From [REDACTED]
Sent: 03 October 2019 15:47
To: Planning.Responses <Planning.Responses@arun.gov.uk>
Subject: A/122/19/OUT Land off Arundel Rd BN16 4ET PA/19/SE/AR/53493
Importance: High

Thank you for consulting Sport England on the above outline application.

The application is 'outline' – 160 homes including to 'expand the current sport provision to form a sports hub. The details are limited.

Figure 5.2: Illustrative Masterplan.

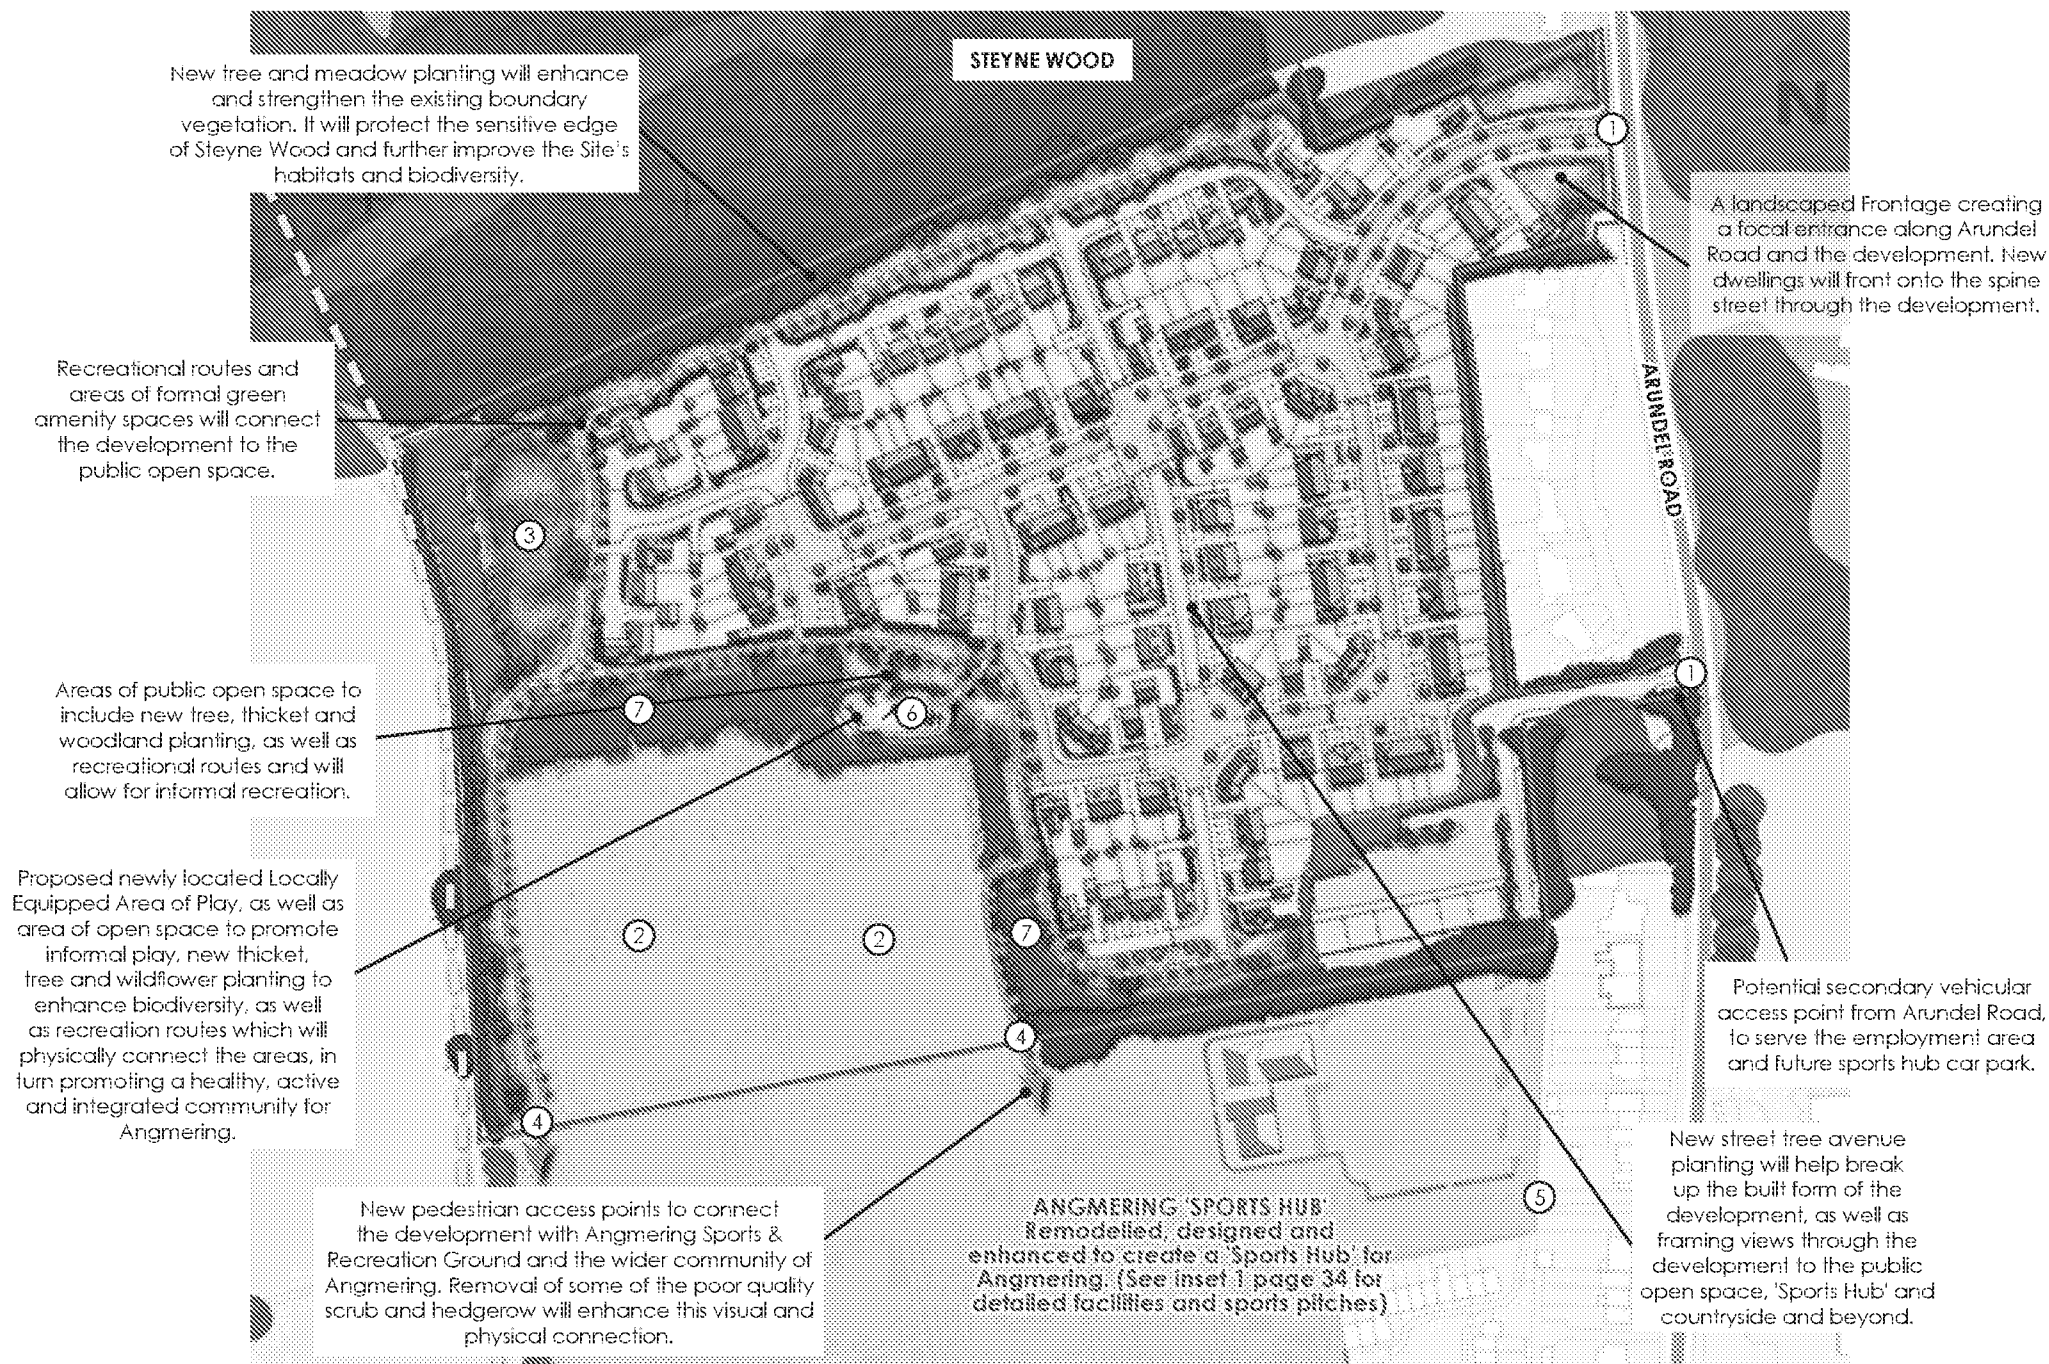
For the proposed relocation of the cricket pitch the ECB would require a non turf pitch to be installed from the ECB list of Approved Systems. The ECB recommend that a sinking fund be established to provide for the maintenance of the non turf pitch when the warranty period expires.

In terms of the boundary size, the ECB would want to see a minimum boundary of 45.72m (as shown in the attached diagram).

The ECB are pleased to see that a new pavilion is proposed to replace the current building which is no longer fit for purpose. The ECB would want to see compliance with our technical specification for pavilions and clubhouses (especially with regard to changing room location to provide line of sight to the playing area and changing room sizes) and those of Sport England

especially with regard to accessibility. We would highlight that the proposed location of the new building is a considerable distance from the cricket playing area.

Rather than provide, 2 new full size grass pitches, consideration should be given to provide a 3G football pitch.
